**WELWYN HATFIELD BOROUGH COUNCIL
EXECUTIVE DIRECTOR - PLANNING, PUBLIC PROTECTION AND GOVERNANCE**

DELEGATED APPLICATION

Application No: 6/2021/2791/HOUSE
Location: 28 Theobalds Road Cuffley Potters Bar EN6 4HQ
Proposal: Conversion of loft to habitable space including roof alterations, the addition of side dormers and the erection of a part first floor and part single storey side and rear extension
Officer: Ms Emily Stainer

Recommendation: Granted

DRAWING NO.	PROPOSED DRAWINGS
DRAWN BY	
CHECKED BY	
SCALE	AS SHOWN
DATE	03 SEPT 2021

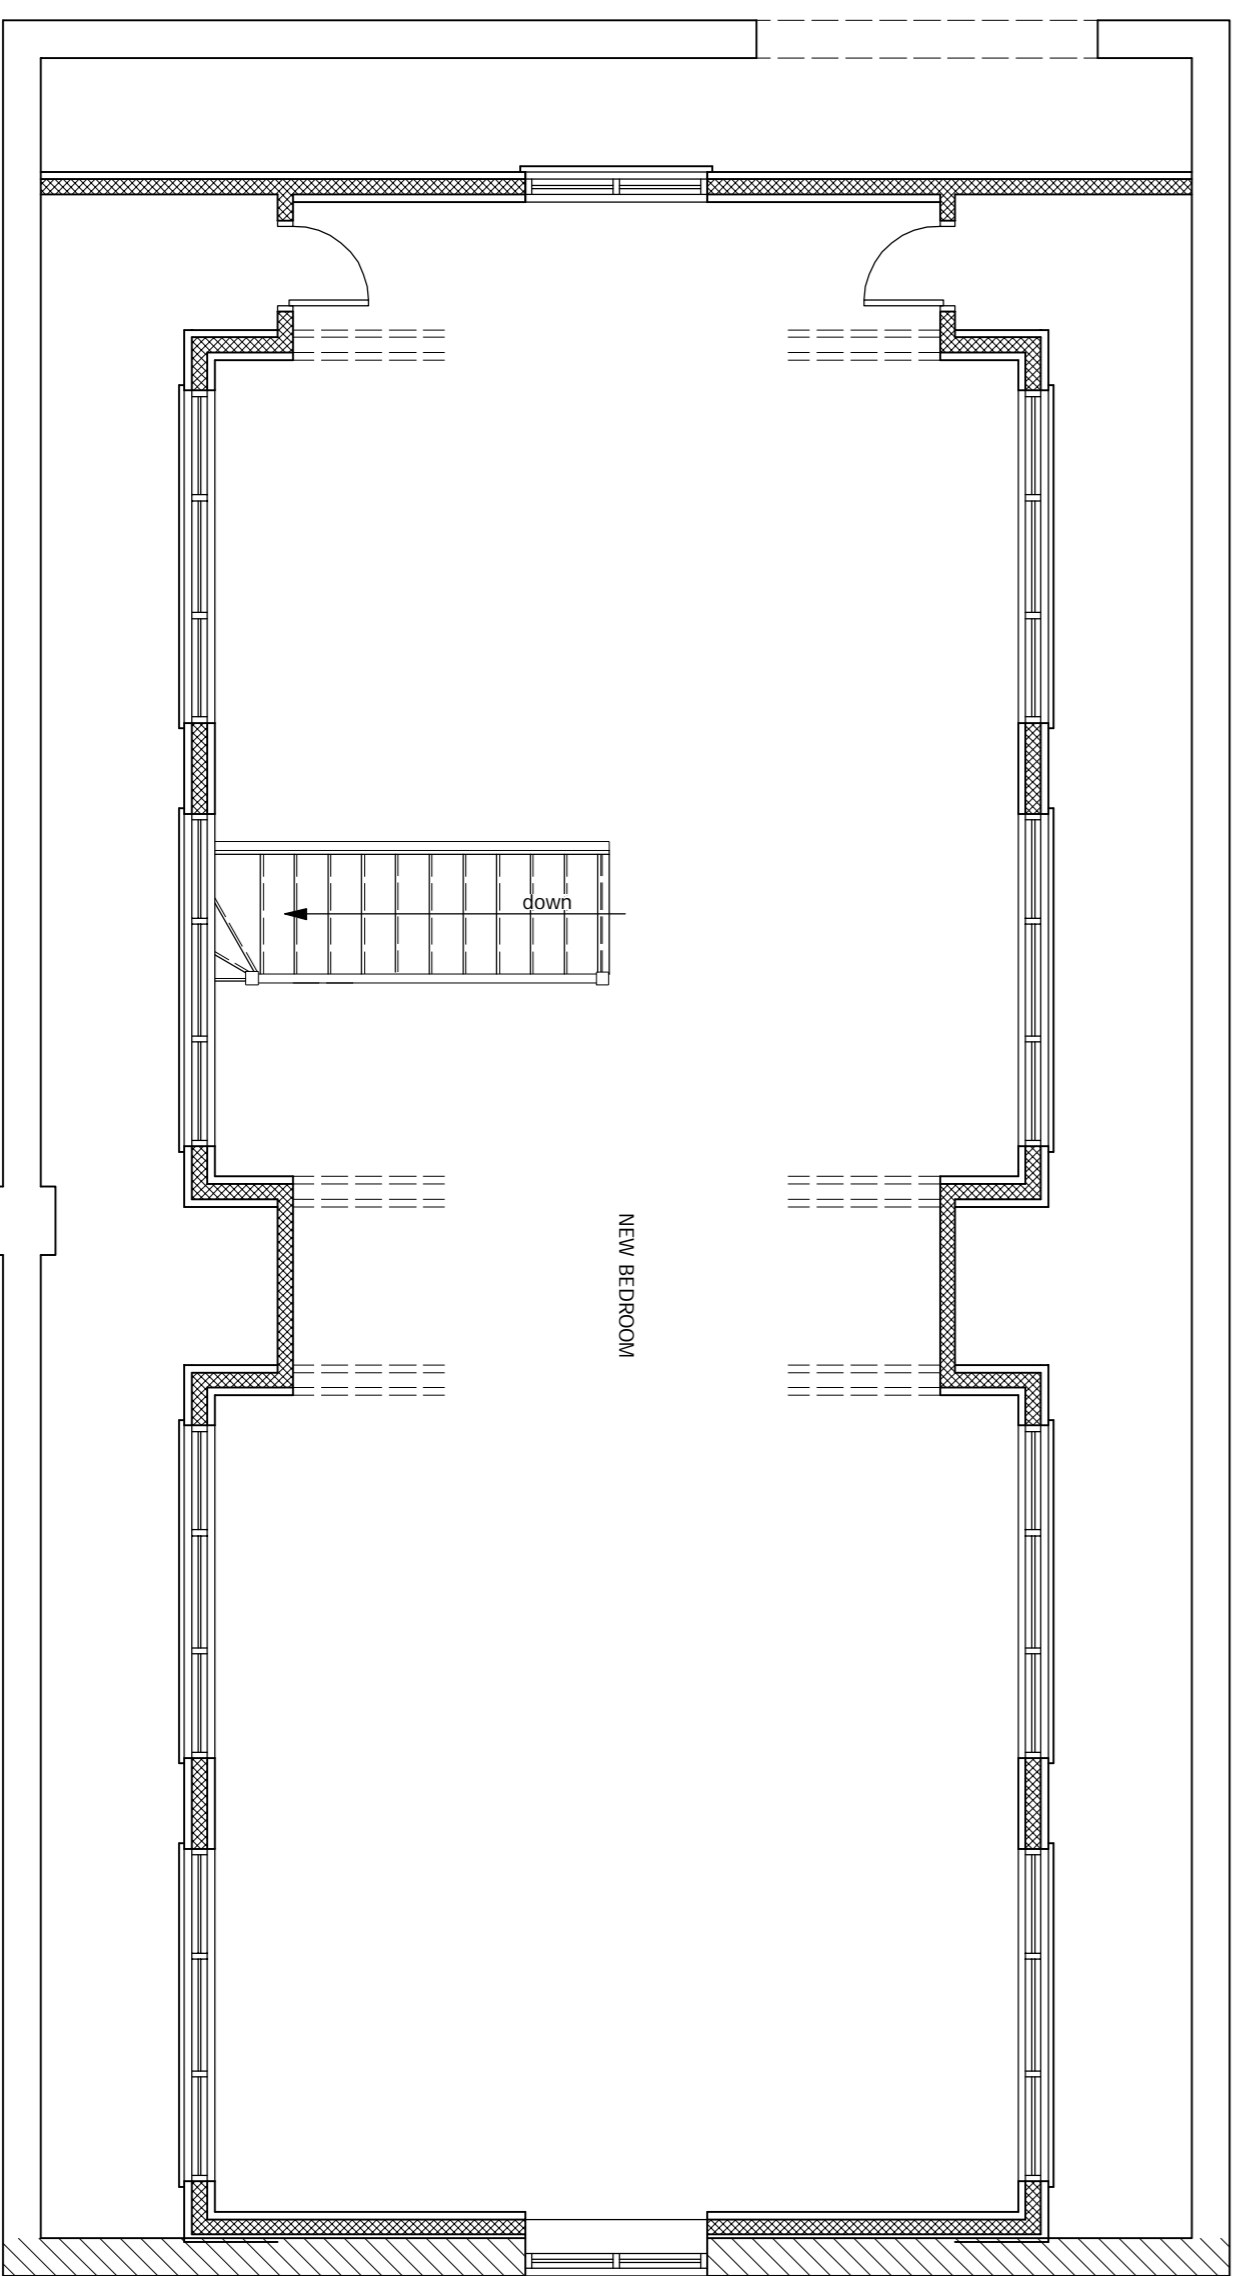
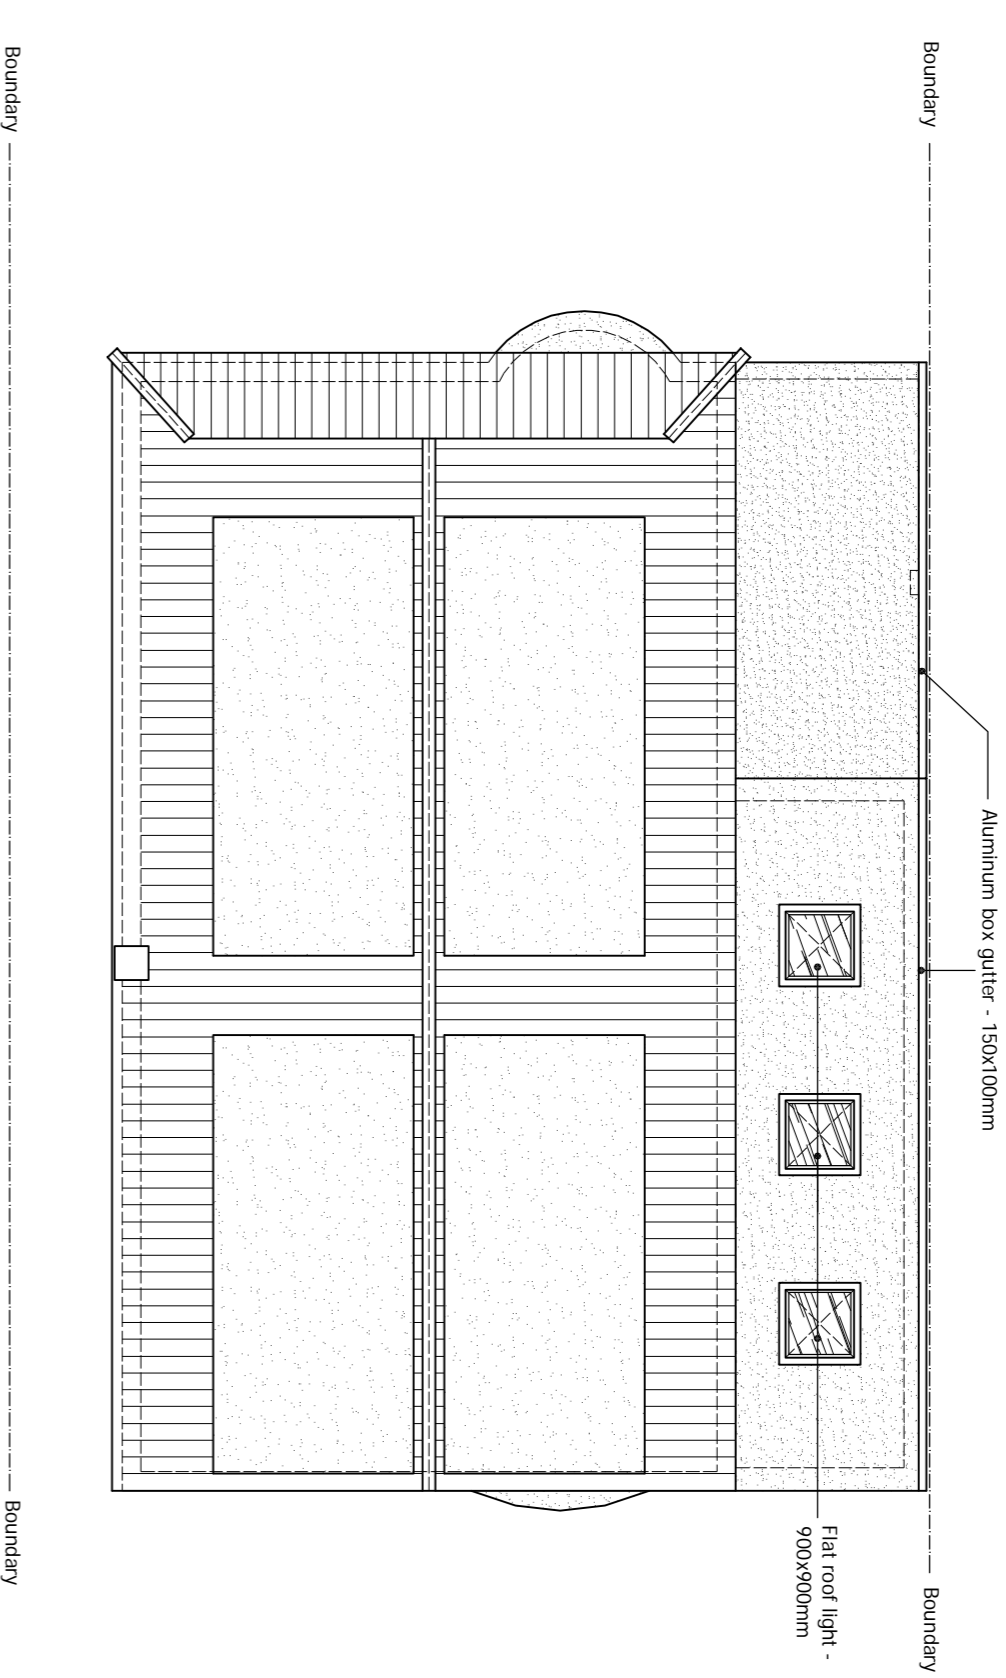
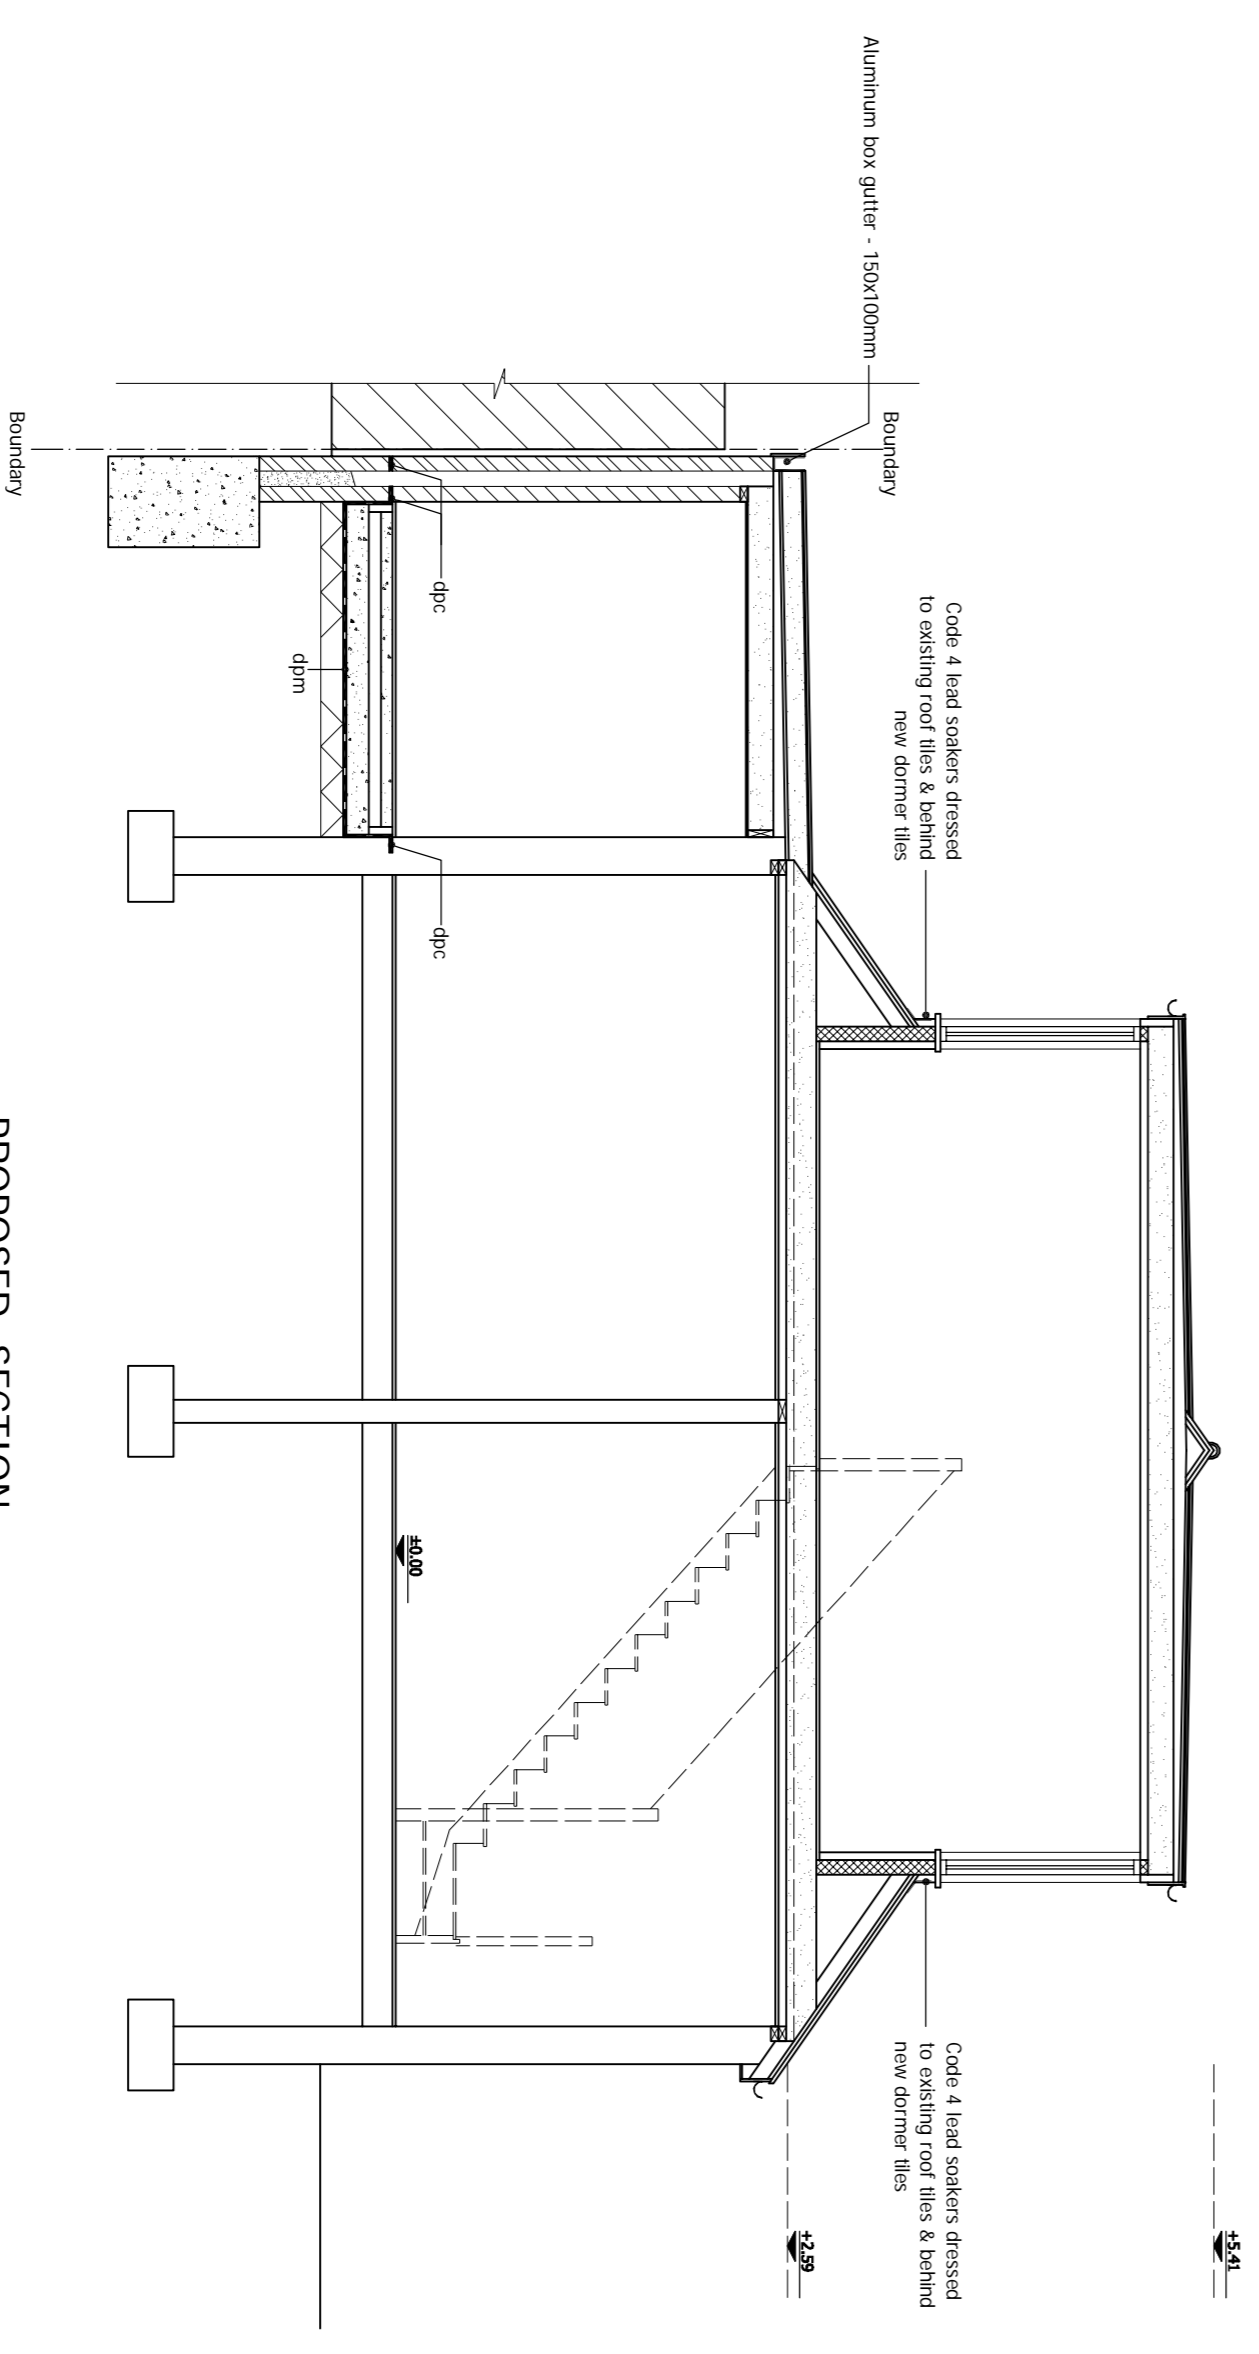
Comment (if applicable): Policies D1 and D2 of the adopted Welwyn Hatfield District Plan (2005) are of relevance and seek to provide a good standard of design in all new development and require that all new development respects and relates to the character and context of the area in which it is to be sited. These policies are expanded upon in the Council's Supplementary Design Guidance (SDG). Policy SP9 of the Emerging Local Plan and the NPPF are similar in these aims. The application property is currently single storey and benefits from a garage to the side and a single storey rear extension. Permission is sought to extend the dwelling at first floor and single storey and convert the loft to habitable space by extending it via the addition of dormers and roof alterations. Theobalds Road and surrounding roads such as Northhaw Road East predominantly consist of single storey bungalows of a similar style to the application dwelling, with simple hipped roofs. Over time, a number of these properties have been extended and the loft space converted to create habitable accommodation at first floor level. Front, side and rear dormers, rooflights and gable windows are common on these properties which have been converted and there are also examples of rear extensions which extend off the main ridgeline of the host property. Although the proposed extension to the rear would not be subordinate by virtue of its continuation of the ridgeline of the main house, there are numerous examples of similar extensions nearby due to the restricted nature of extending a single storey bungalow. The proposed dormers have been amended during the course of this application. Originally, two

dormers were proposed on each side of the building, each with two windows. The combined width of the initial dormers on each side would have been approximately 11.8m (5.9m in width) and a height of approximately 1.8m. The amended design includes a single dormer on each side which would measure approximately 10m in width and would be set in from the front and rear of the roofslope by at least 1m. Each dormer would only benefit from two windows and they have been reduced in size from the previous proposal in order to integrate better with the fenestration pattern on the existing house. The amended design is considered to be more appropriate to the existing dwelling and to the context in the surrounding street scene. The plans state that roof tiles, brickwork and render will match existing but there are limited details in respect of window/door materials. Therefore, a condition will be imposed which ensures the materials match existing.
